Department of Planning, Industry and Environment,
Major Projects

Re: Development Applications SSD 8925
The new Sydney Fish Market - Stage 2

I object to the development as proposed on the following grounds:

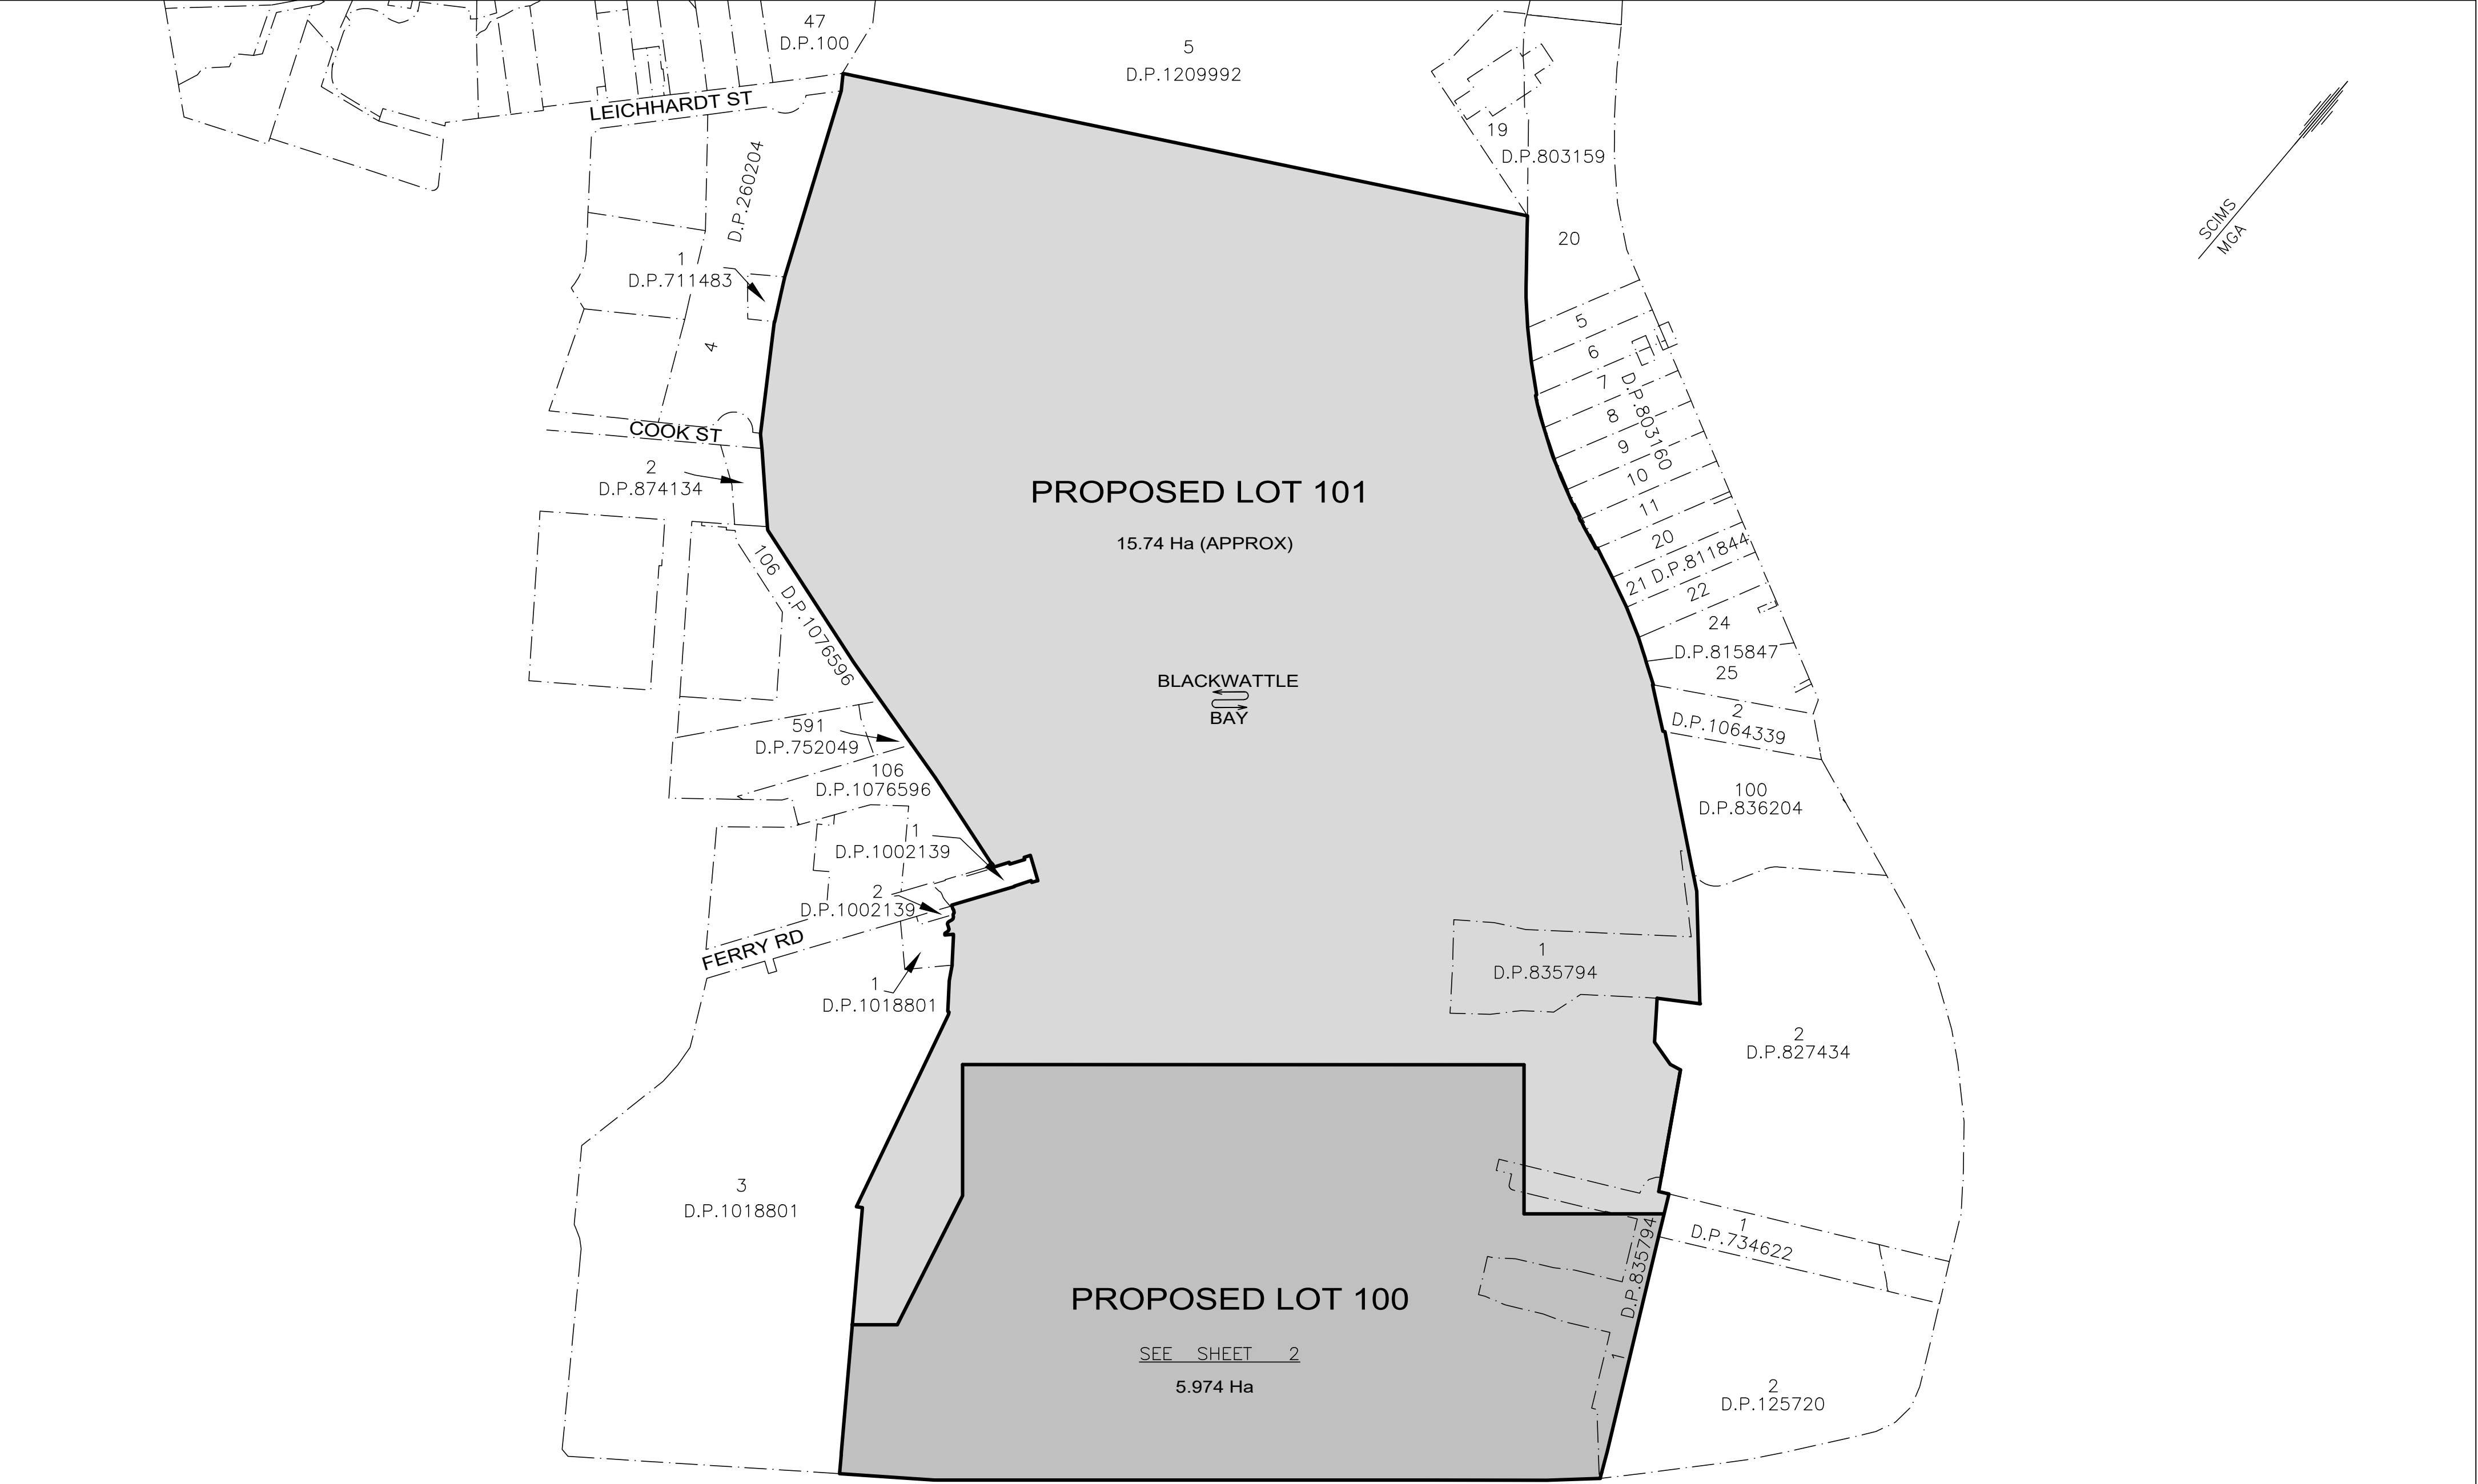
The footprint of the building is huge jutting into Blackwattle Bay over 110 m. (see *Plan of Subdivision of proposed lot 101, sheet 1 of 7*).
